Case Officer: Catherine Harker **Recommendation:** Approve

Applicant: Mr D & Mrs A Brace

Proposal: Single storey extension and various internal alterations. New windows and rooflights

Drawing Title:  
Proposed First and Second Floor Plans

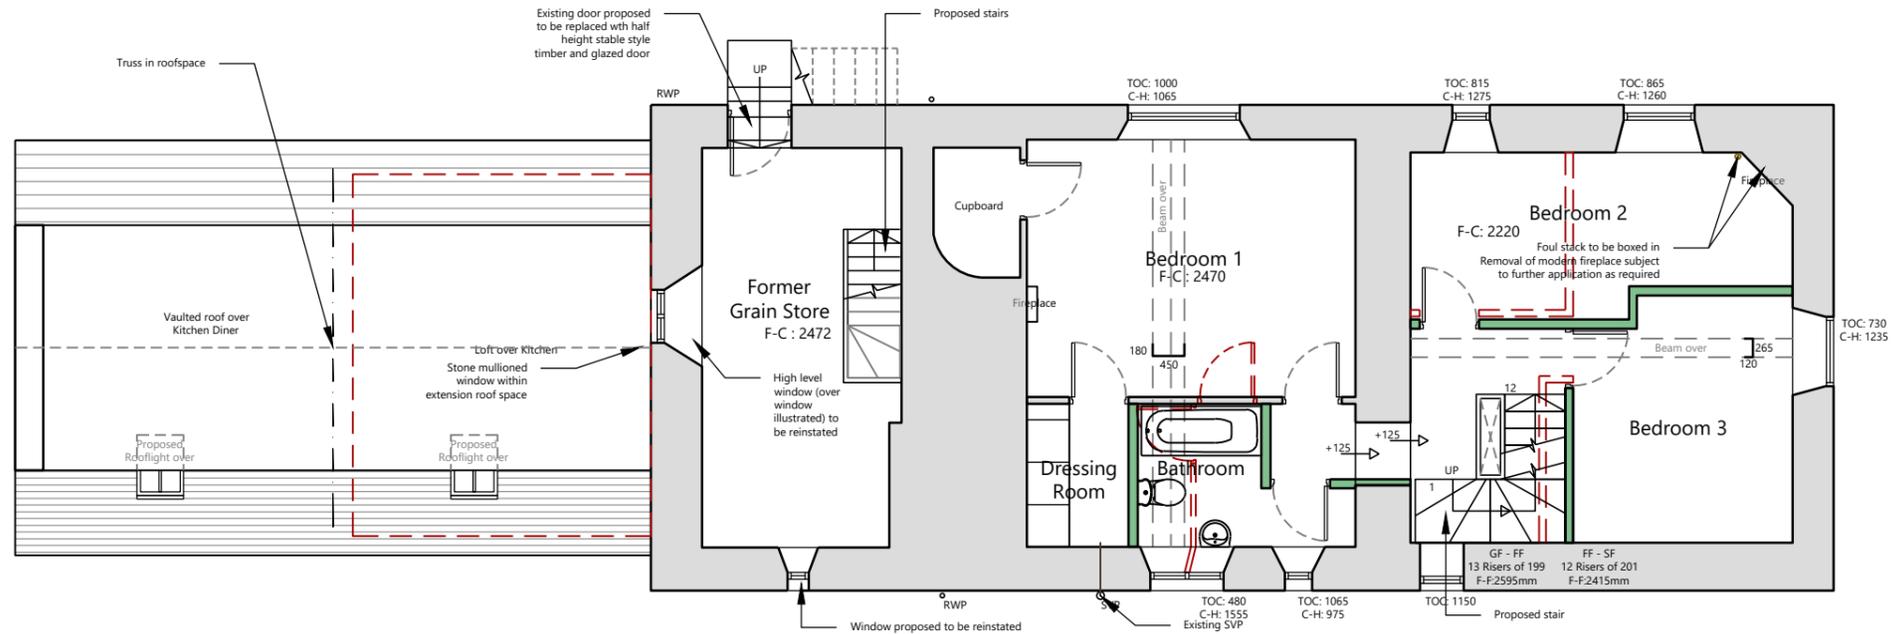
- Object to the large rooflight to the attic of the main house but would accept a modest flush conservation rooflight set between the rafter and with a central glazing bar.*

- New WCs –please show any SVP/dergo that may affect internal or external fabric.*

- New stair –details will be required for both stairs to ensure minimum harm to any historic timbers.*

- 8.6. The drawings have been amended to reflect the Conservation Officer's concerns, including the rooflight to the main house given a smaller, more vertical form, and the rear door to the main house and side door to the extension changed to match that shown in the Conservation Officer's comments.

Drawing Title:
Proposed West and South Elevations

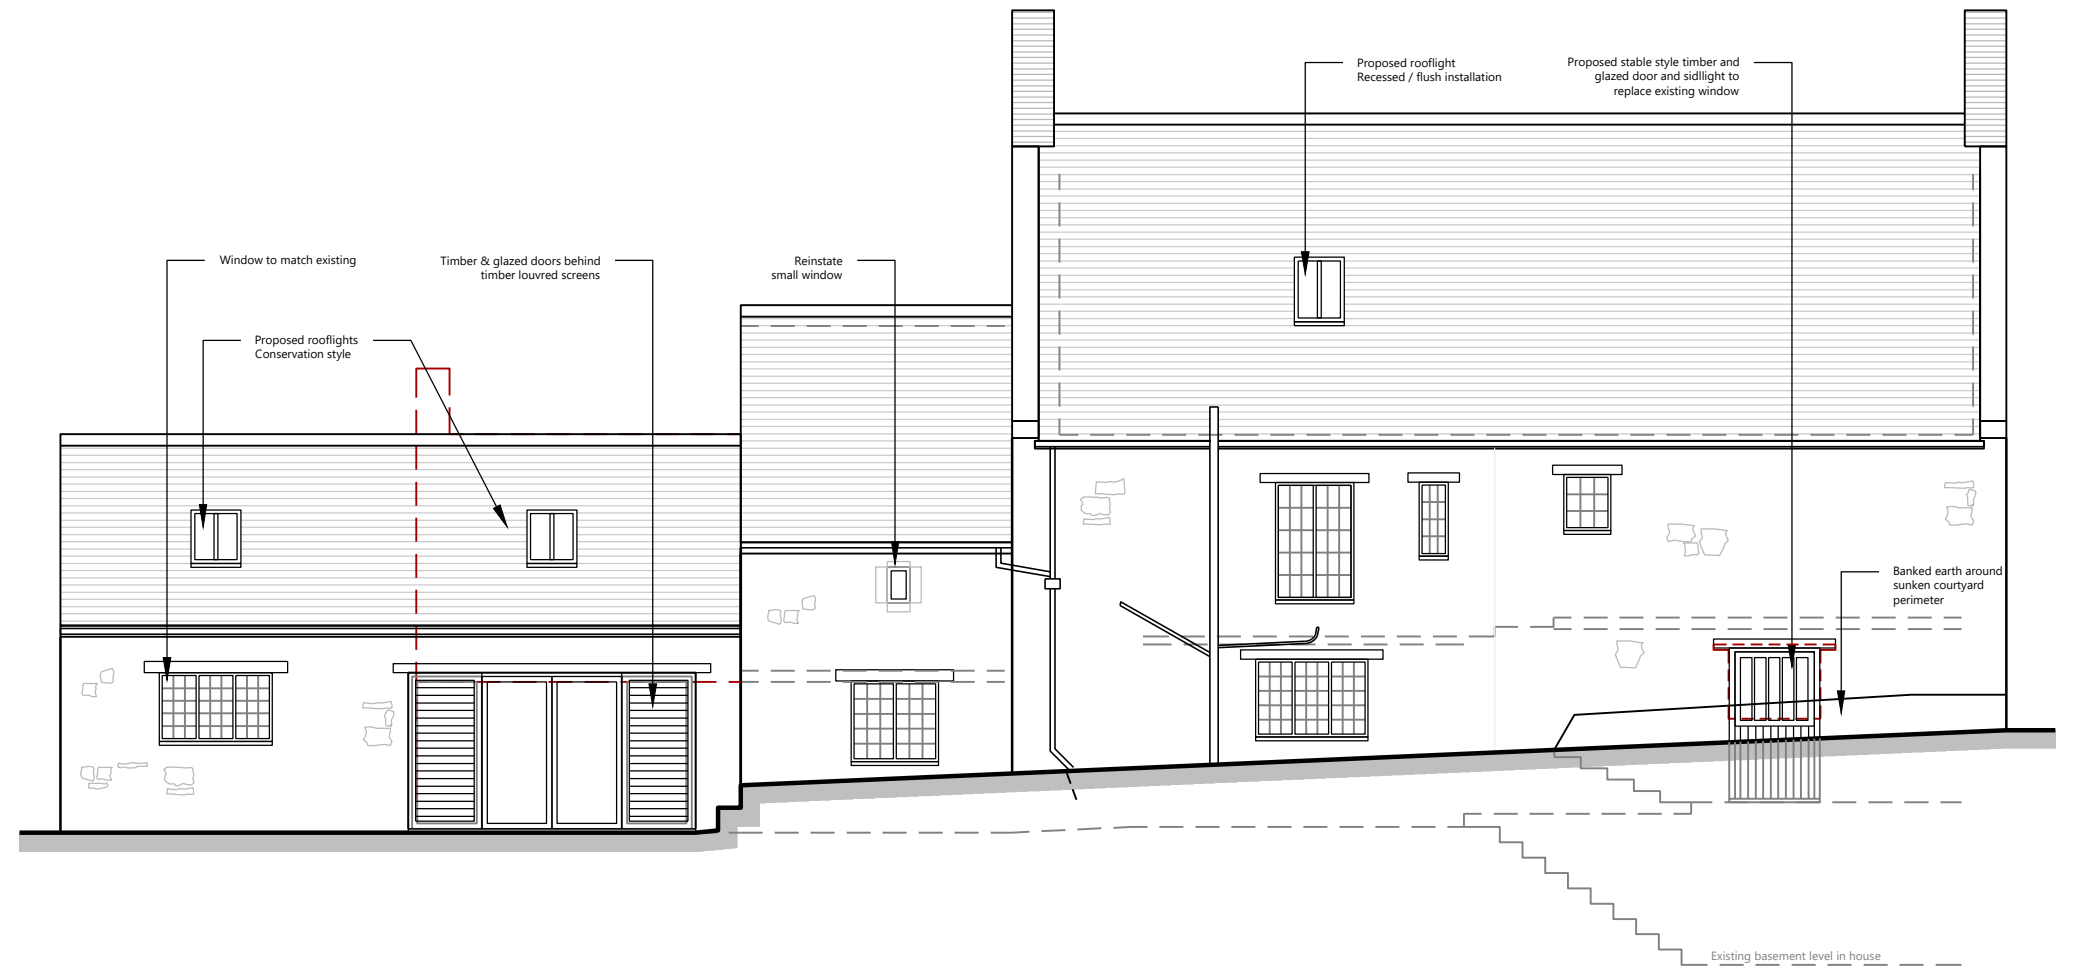
- Object to the rooflights on the extension and the proposed double grouping reinforces this would not respect the listed building. A high level gable light would*

- I do not support the proposed side light to the stable doors in the gable or the main house, or the large glazed upper to the granary door. I would rather see a wider door with glazed top if well detailed, to avoid the side light proposed. The first image below has a framed flush boarded panel, the top could be divided into traditional panes –this would avoid the typical mid cill seen on a typical stable door interpretation which is a less successful detail. Could we condition the door details notwithstanding what has been submitted or do we need to negotiate these now? We will also need ironmongery details.*

- External timber screens –will these slide over all the glazing to reduce lightspill or are they decorative? We will need details.*

Main house rooflight, this is too wide and needs to have a vertical proportion.

Kitchen/dining extension rooflights:

I would accept a single modest rooflight (with central glazing bar – vertical proportion) centrally over the sink and another over the table.

Will these be moveable or fixed?

- 8.7. The number of rooflights in the extension has been reduced, with 2 to the rear of the extension and none to the front, and the design lent a more vertical design with the use of central glazing bars as suggested by Conservation.

- 8.8. The agent is unable to provide details regarding the windows or louvres at this time, and a condition regarding these will be imposed. Likewise, further details of the landscaping related to the ground work and earthwork to create the door and steps down will be required.

Drawing Title:
Proposed West and South Elevations

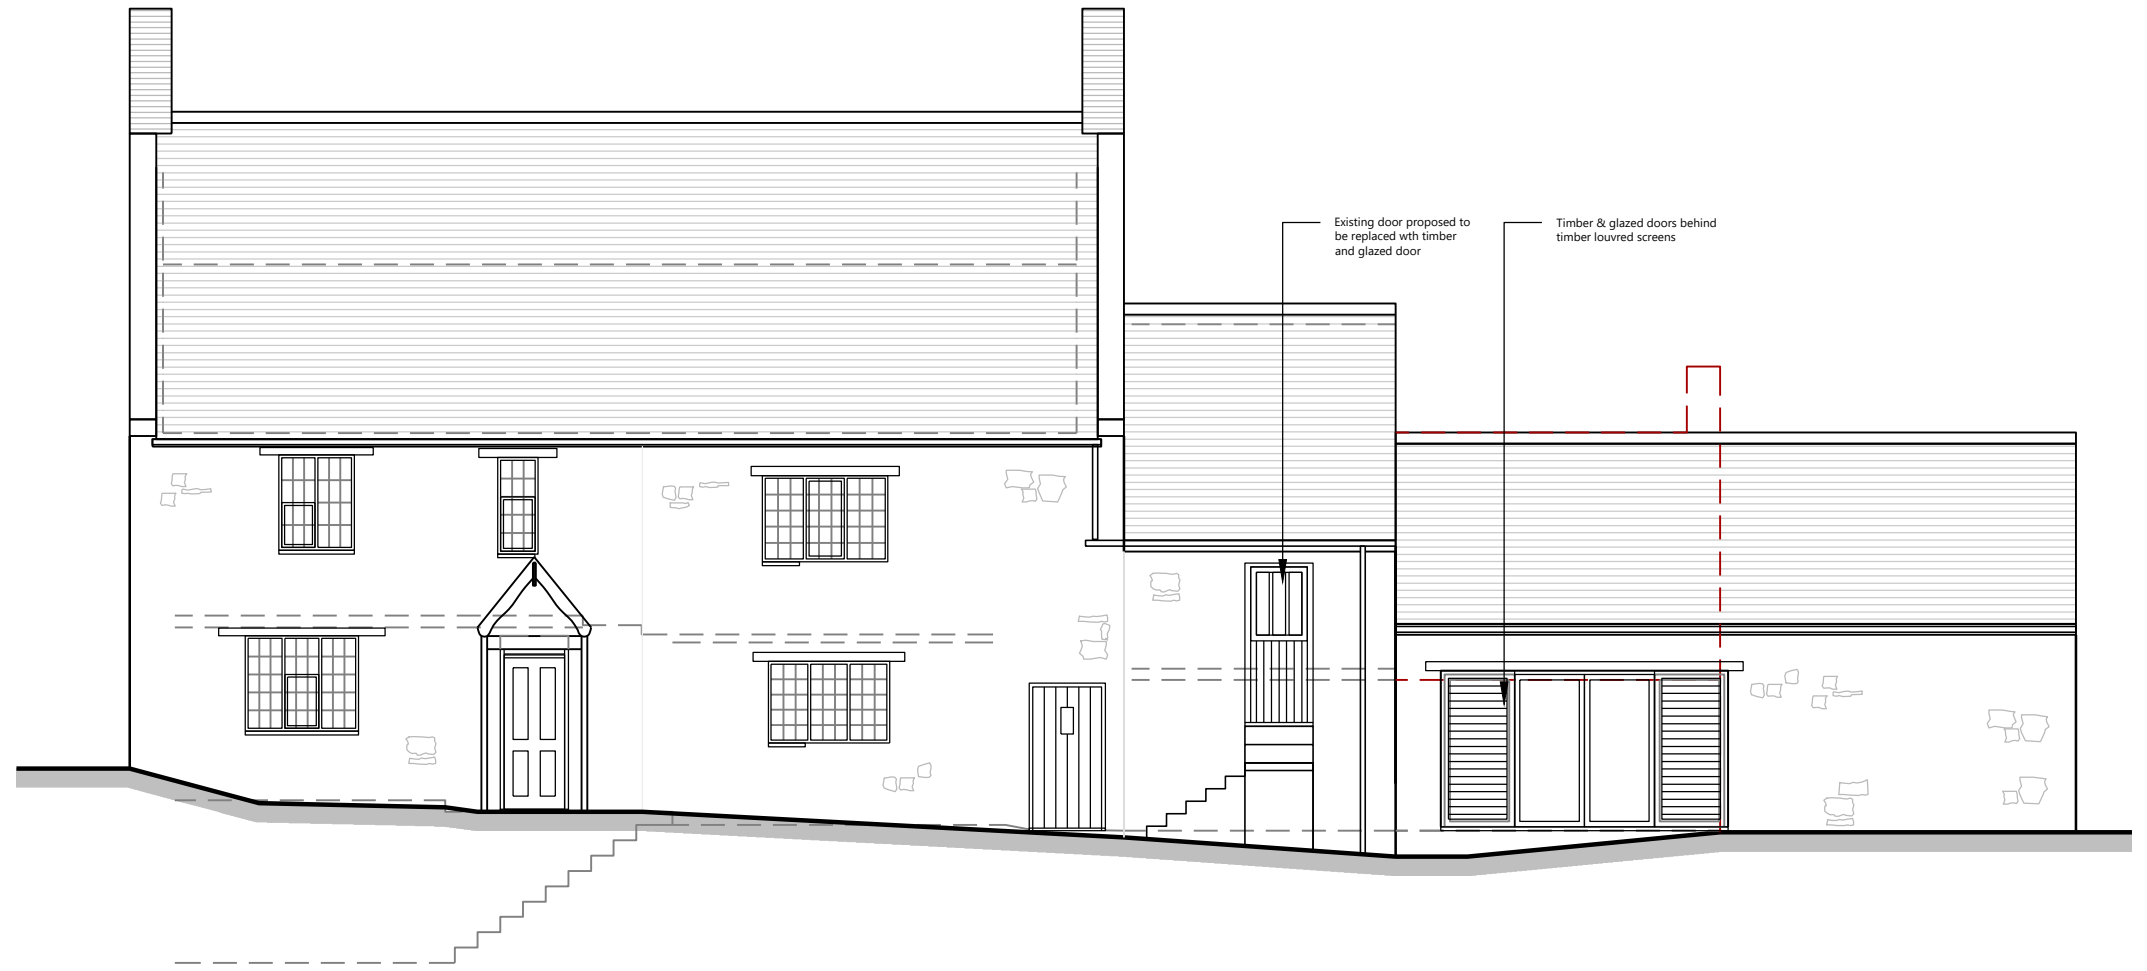
- Whilst there are boxed eaves to the main house and the granary, a flush traditional eaves as per the extension to be demolished should be followed.*
